A1 in Northumberland: Morpeth to Ellingham

7.5 E Statement of Common Ground: Forestry Commission

**STATEMENT OF COMMON GROUND: FORESTRY
COMMISSION**

Version	Date	Status of Version
Rev 0	January 2021	Deadline 1 Version

Figure 1 - Ancient Woodland Strategy Plan

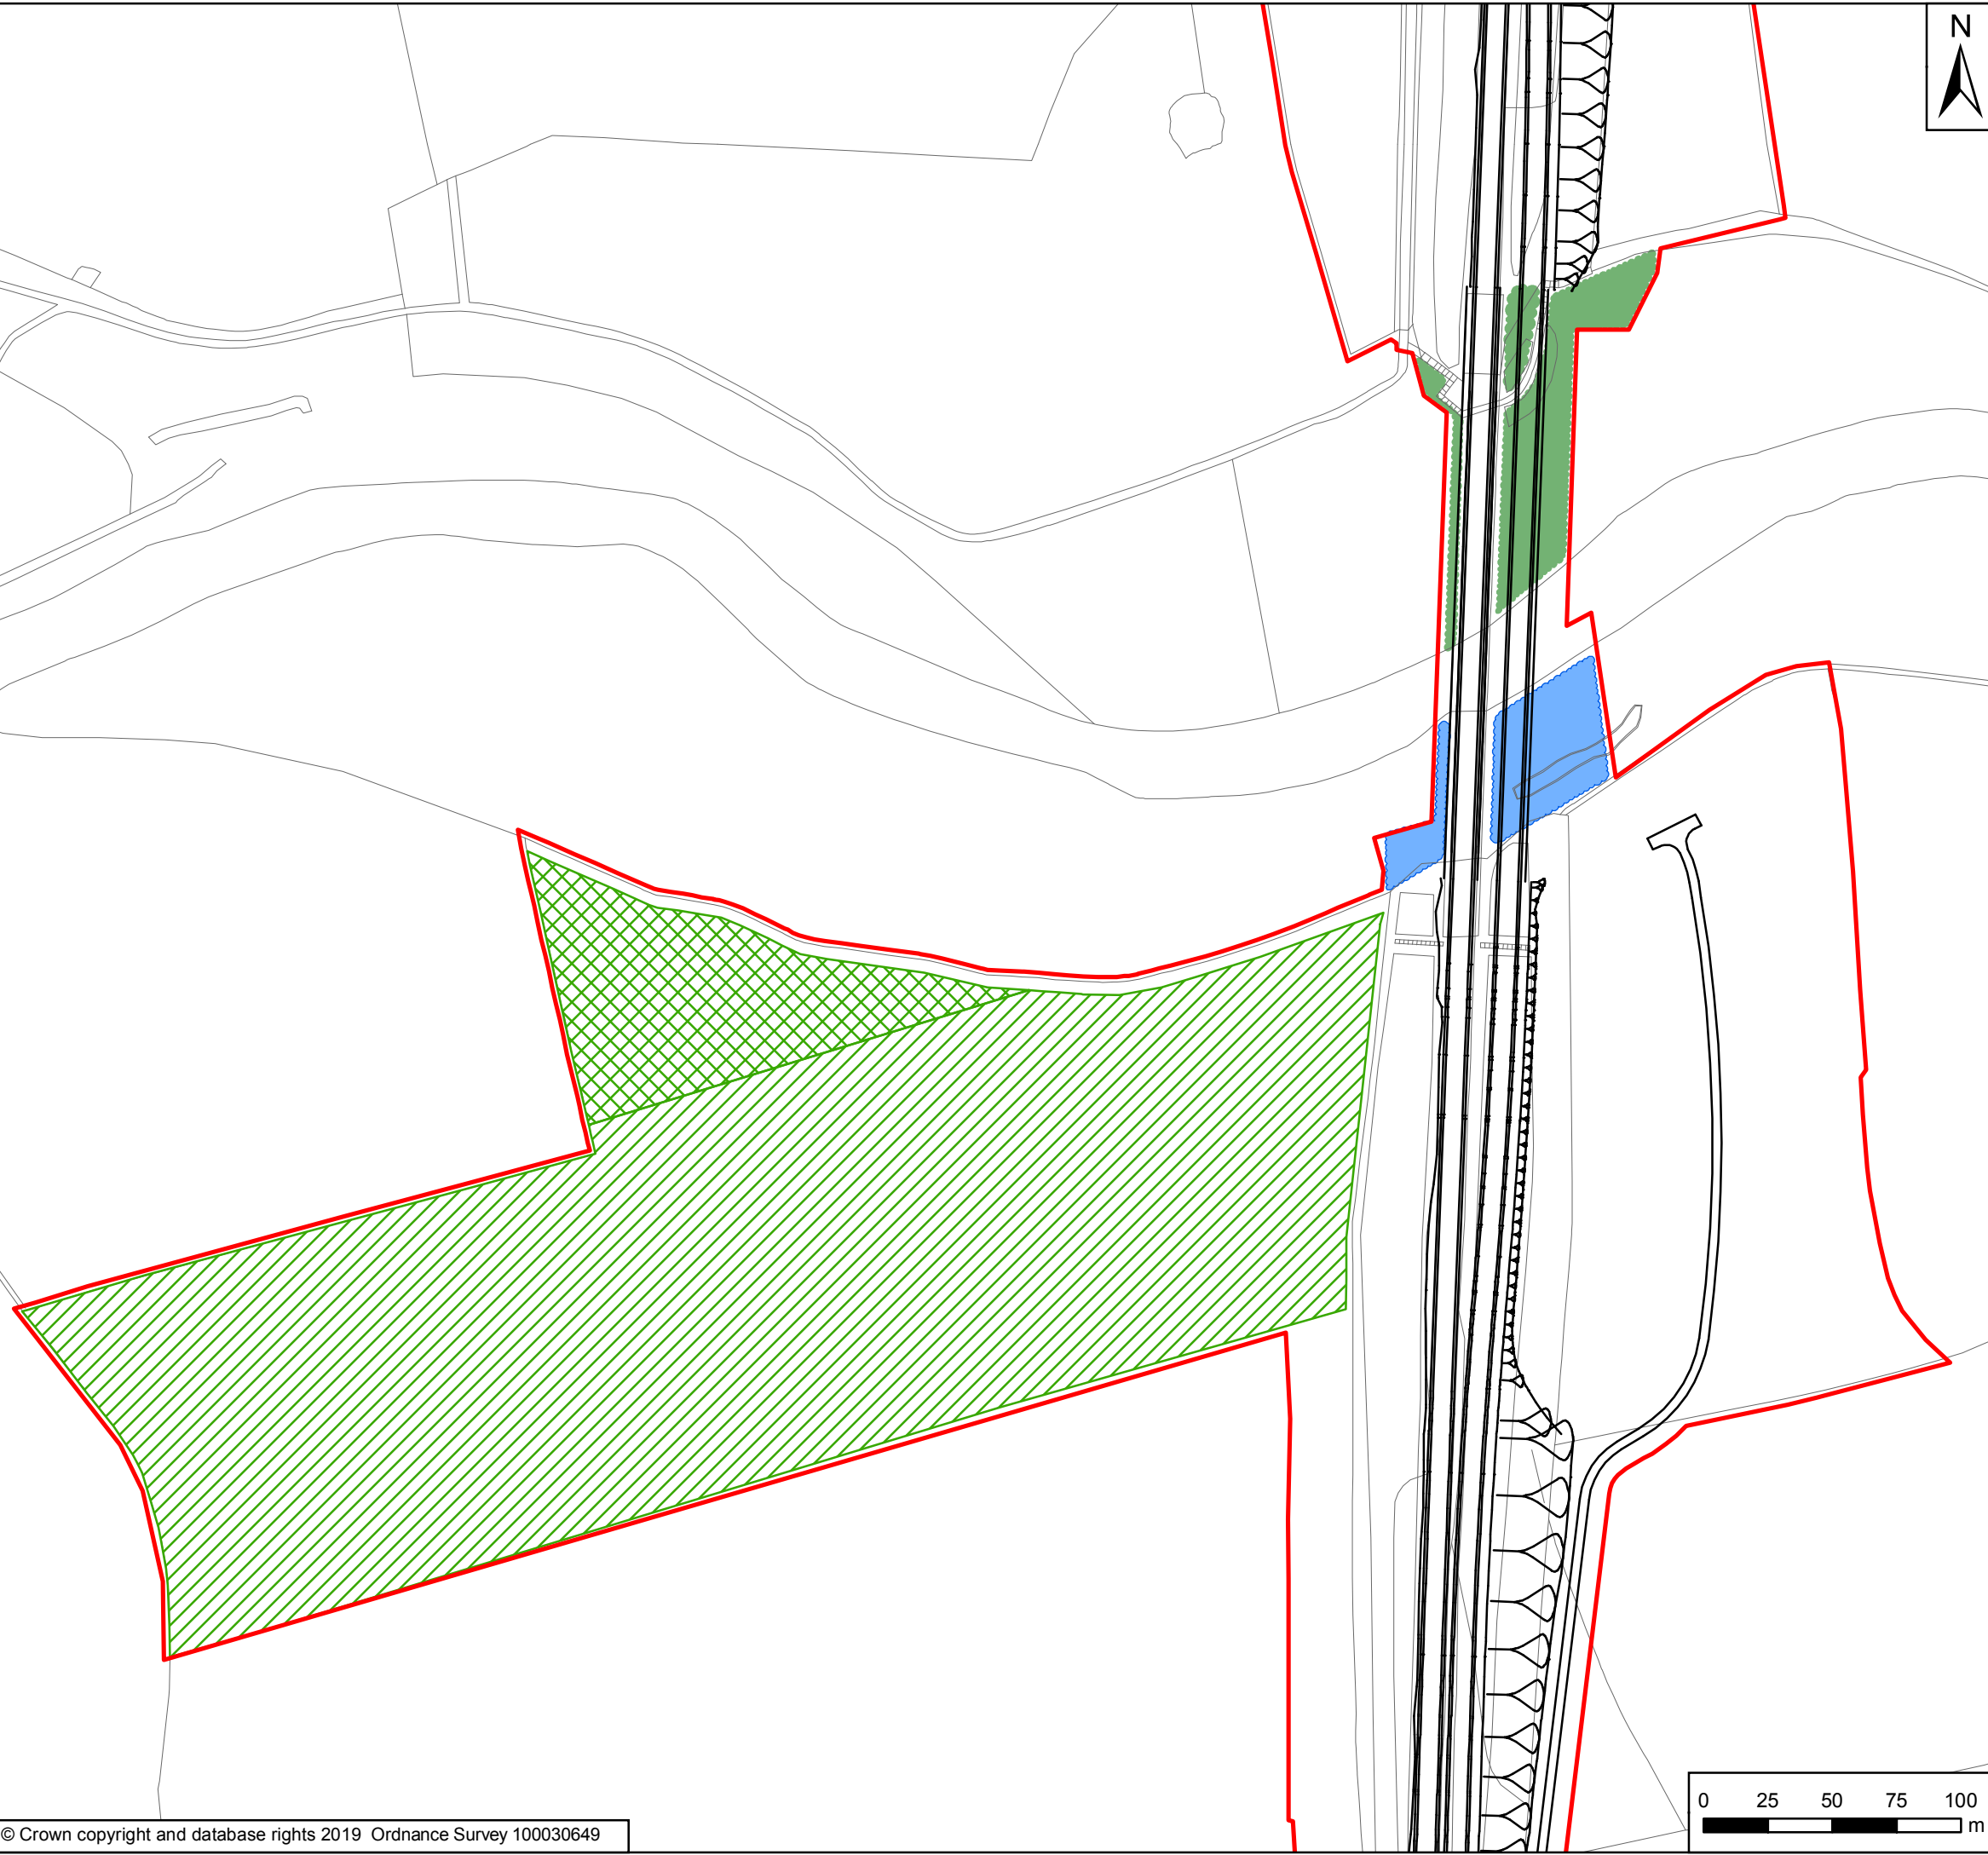
Item	ES Chapter	Paragraph Reference	Forestry Commission Comment	Highways England Response	Status
1.	Environmental Statement - Appendix 7.5 Arboricultural Report Part A	Whole Document	<p>1. Both the Forestry Commission and Natural England consider the partial loss of part of Duke's Bank Wood undesirable.</p> <p>2. Both the Forestry Commission and Natural England highlight the effects of the Scheme on Duke's Bank Wood.</p>	<p>1.The Applicant acknowledges this and accepts a requirement to mitigate the impacts of the Scheme on Duke's Bank Wood.</p> <p>2. The Applicant accepts this, and considers that some impact on this wood is an unavoidable feature of the Scheme.</p> <p>Through the design of the bridge footings and construction working areas the applicant has sought to minimise the loss of ancient woodland as far as it is practical to do so.</p> <p>The applicant has also worked in consultation with Natural England to develop the proposals for compensating for the loss of ancient woodland at the River Coquet. Following discussion between the Applicant's ecology, arboriculture team and Natural England, a strategy of mitigation and compensation, alongside other objectives, has been produced.</p>	Under Discussion, partly resolved.

Item	ES Chapter	Paragraph Reference	Forestry Commission Comment	Highways England Response	Status
			<p>3. The requirement for a management plan with regards to replacement planting was raised by the Forestry Commission and Natural England.</p> <p>4. The Forestry Commission and Natural England agreed that translocation of ancient woodland soils is desirable despite the presence of Ash dieback and the risks were low, given the short distance</p>	<p>This is captured in the Ancient Woodland Strategy [APP-247] that would be secured through measure A-L6 of the Register of Environmental Actions and Commitments contained within the Outline Construction Environmental Management Plan (Outline CEMP) [APP-346] and Requirement 5 of the draft DCO.</p> <p>3. A 12:1 replacement planting ratio of additional woodland to be provided for ancient woodland lost was requested by The Forestry Commission and agreed by the applicant.</p> <p>The submitted Ancient Woodland Strategy [APP-247] incorporates the agreed 12:1 replanting ratio and sets out the requirements of indicative management plan for this replacement planting.</p> <p>4. The Applicant acknowledges a requirement for this to be developed at the detailed design stage. The Ancient Woodland Strategy [APP-247] sets out that suitable biosecurity measures to control the risk of Ash dieback are to be detailed in a Biosecurity Method Statement.</p>
